**Planning Department
Transportation Development Services**

**Re: Duplex Dwelling
172 Monte Largo NE
60-Day Temporary Certificate of Occupancy- Transportation Development
Engineer's/Architect's Stamp dated 3-13-15 (L23-D008)
Certification dated 3-13-15**

TRAFFIC CIRCULATION LAYOUT
(CERTIFICATION: MARCH 13, 2015)

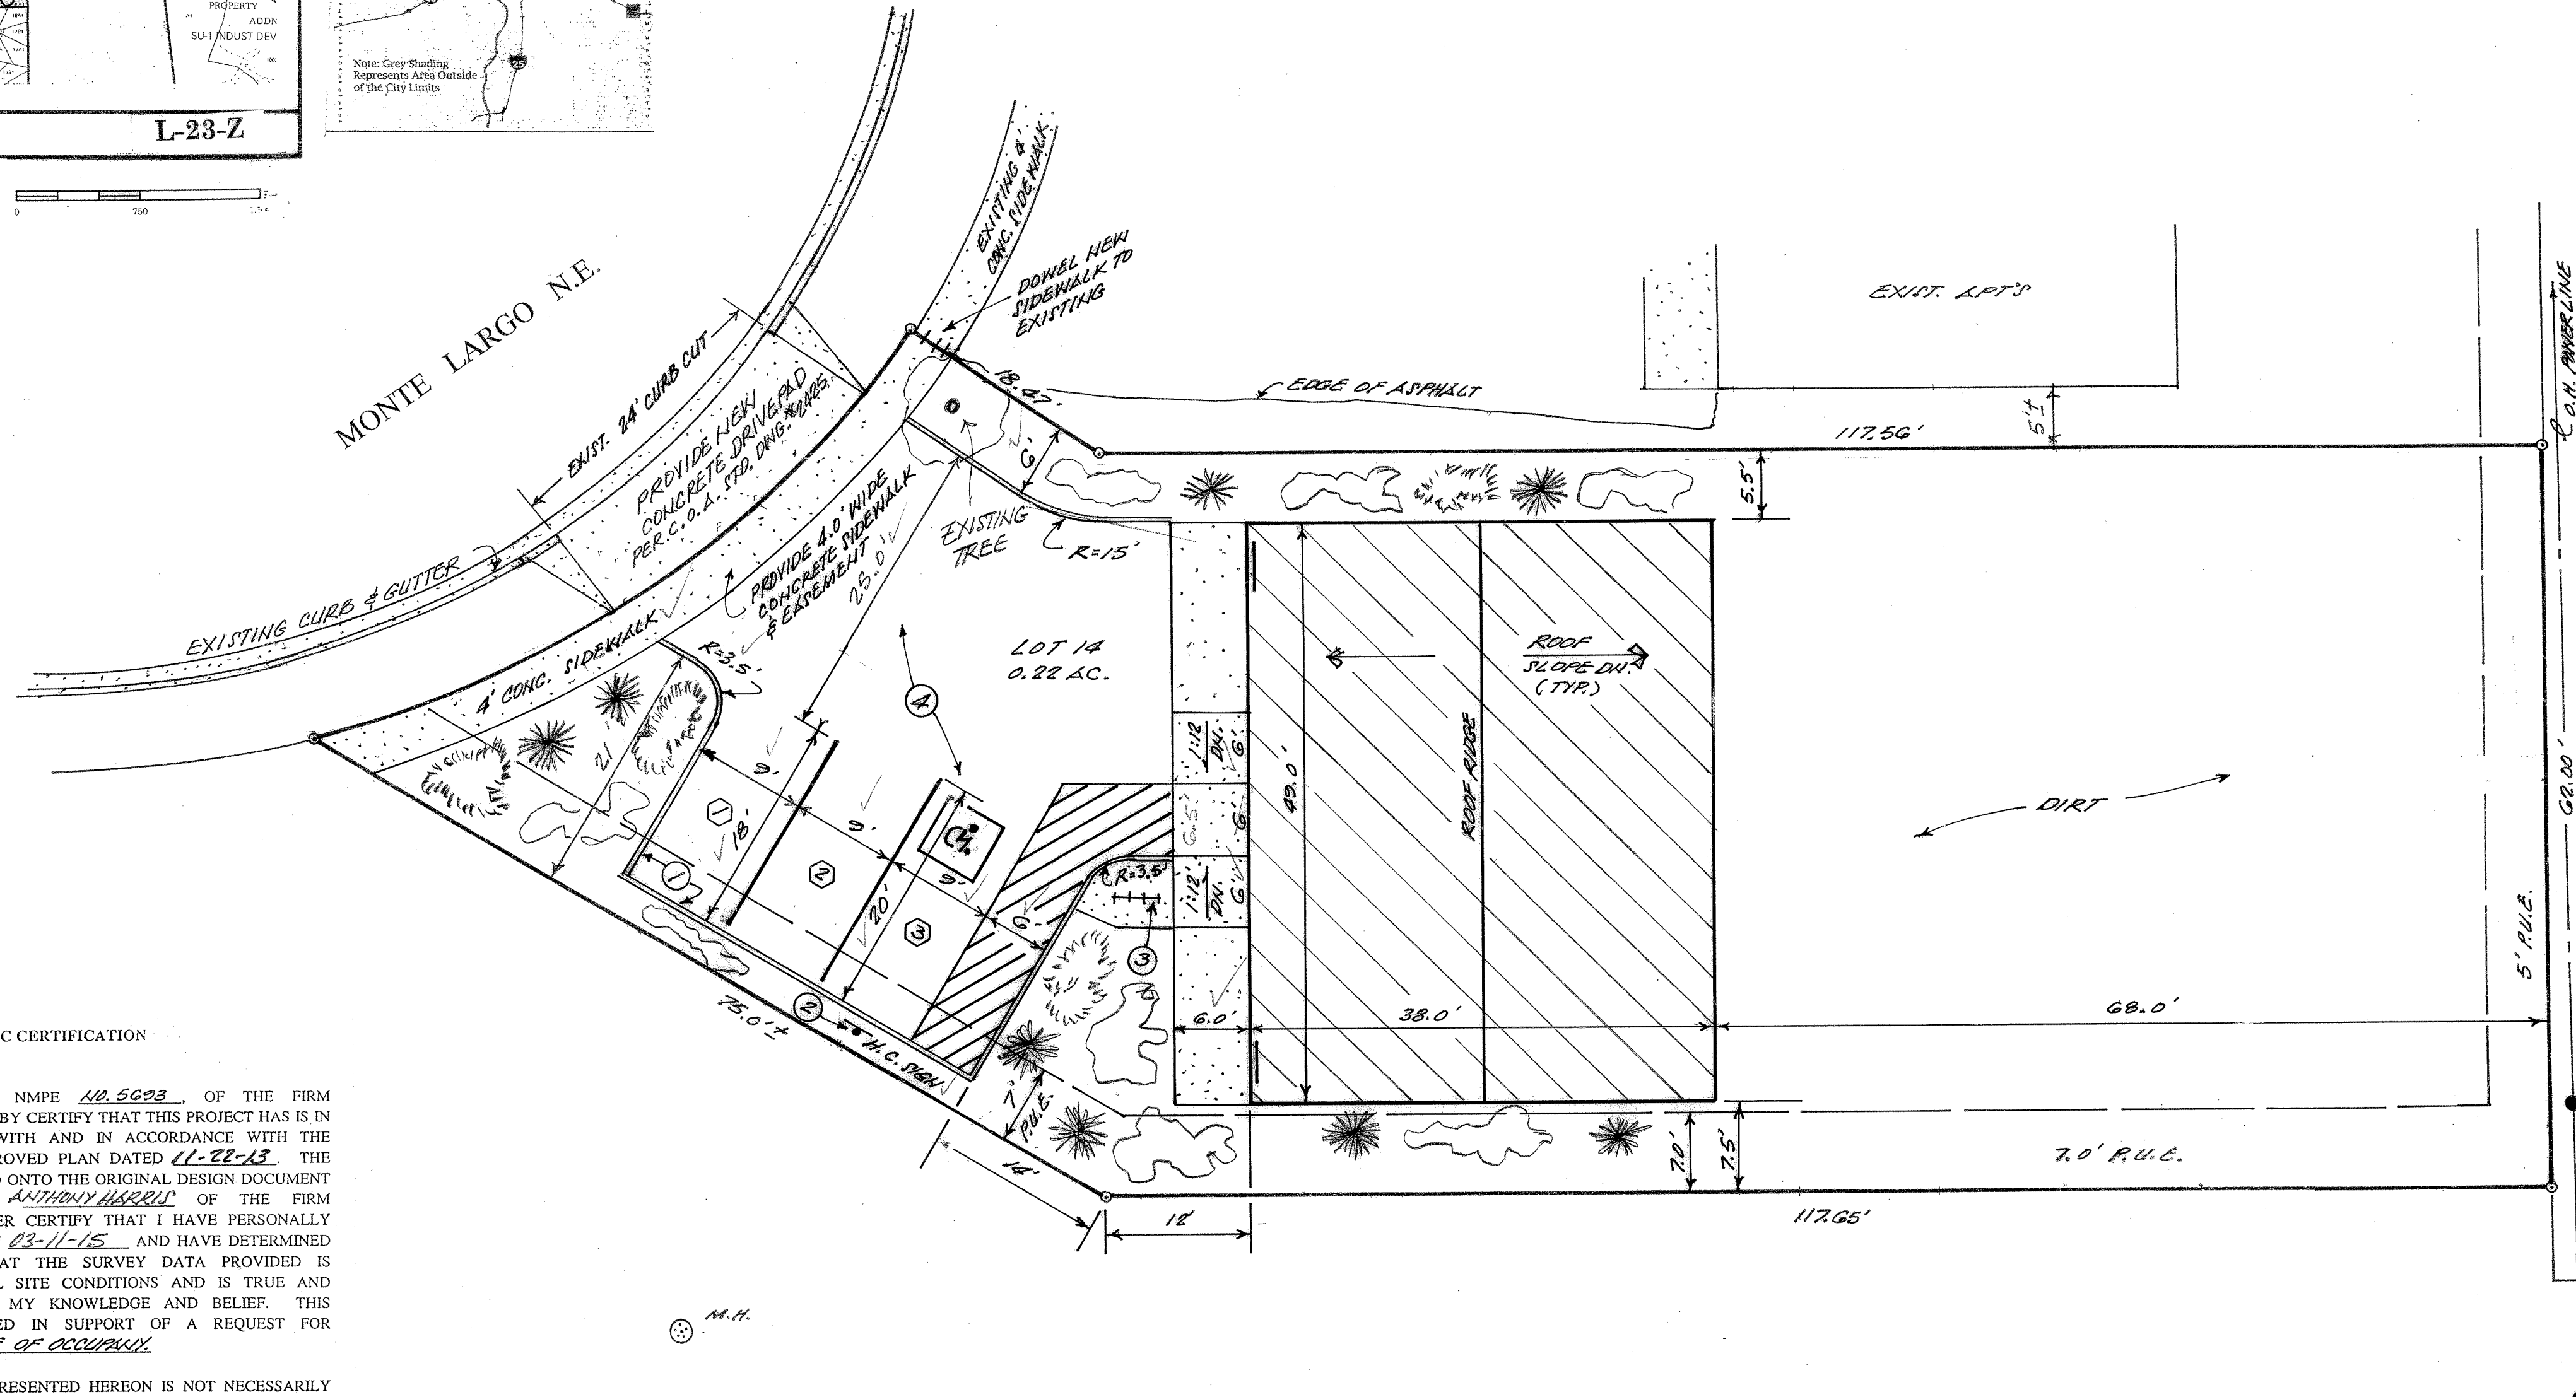
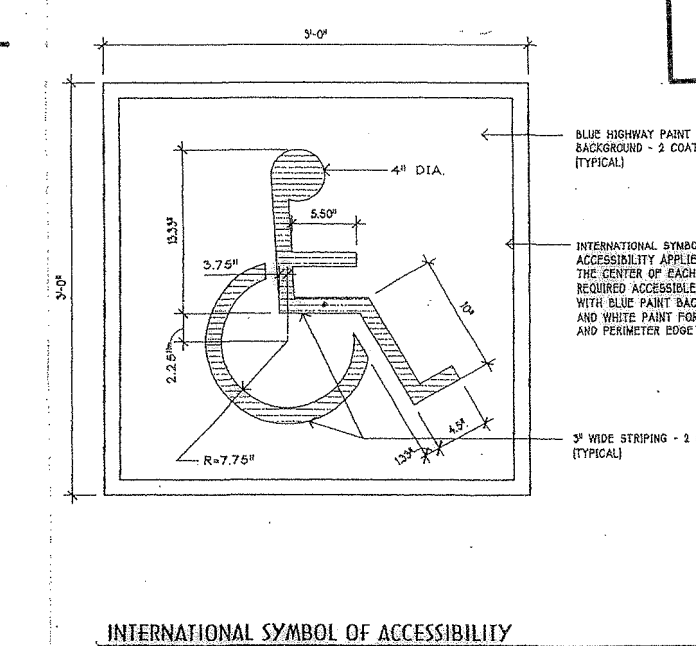
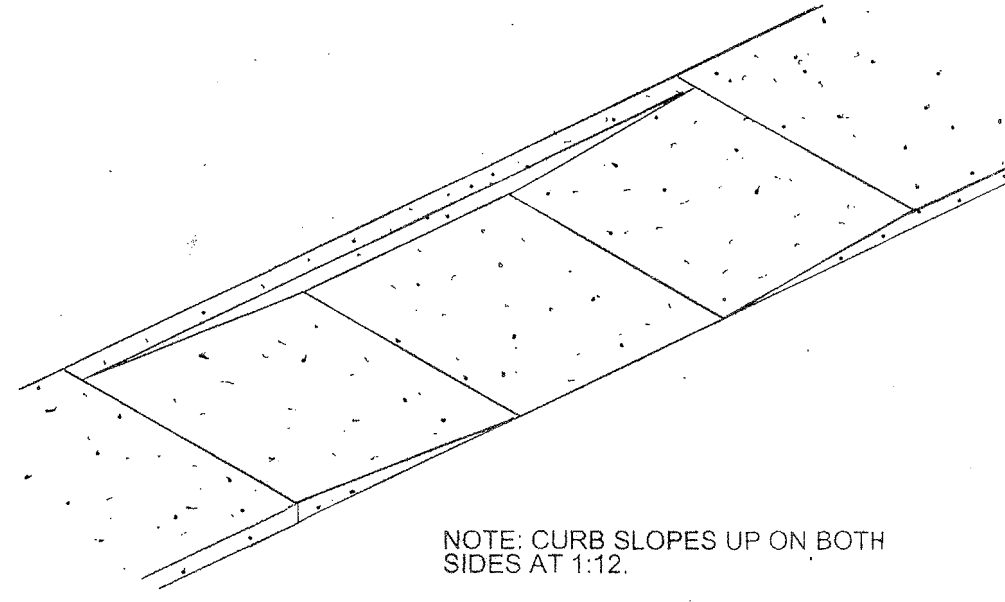
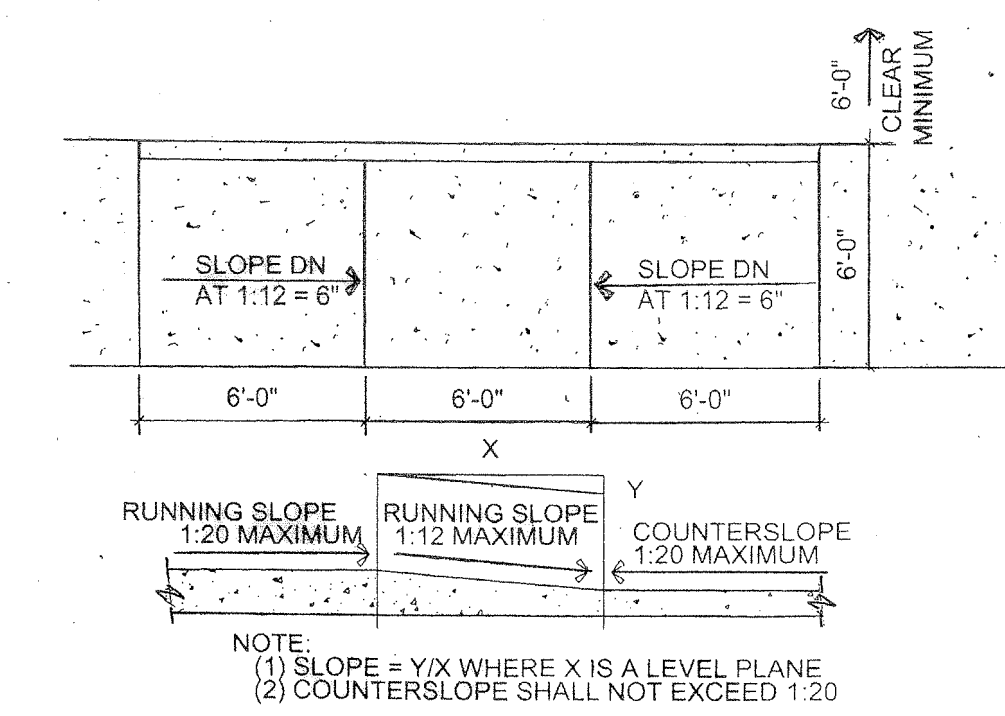
- Installation of ADA sign per TCL plan.
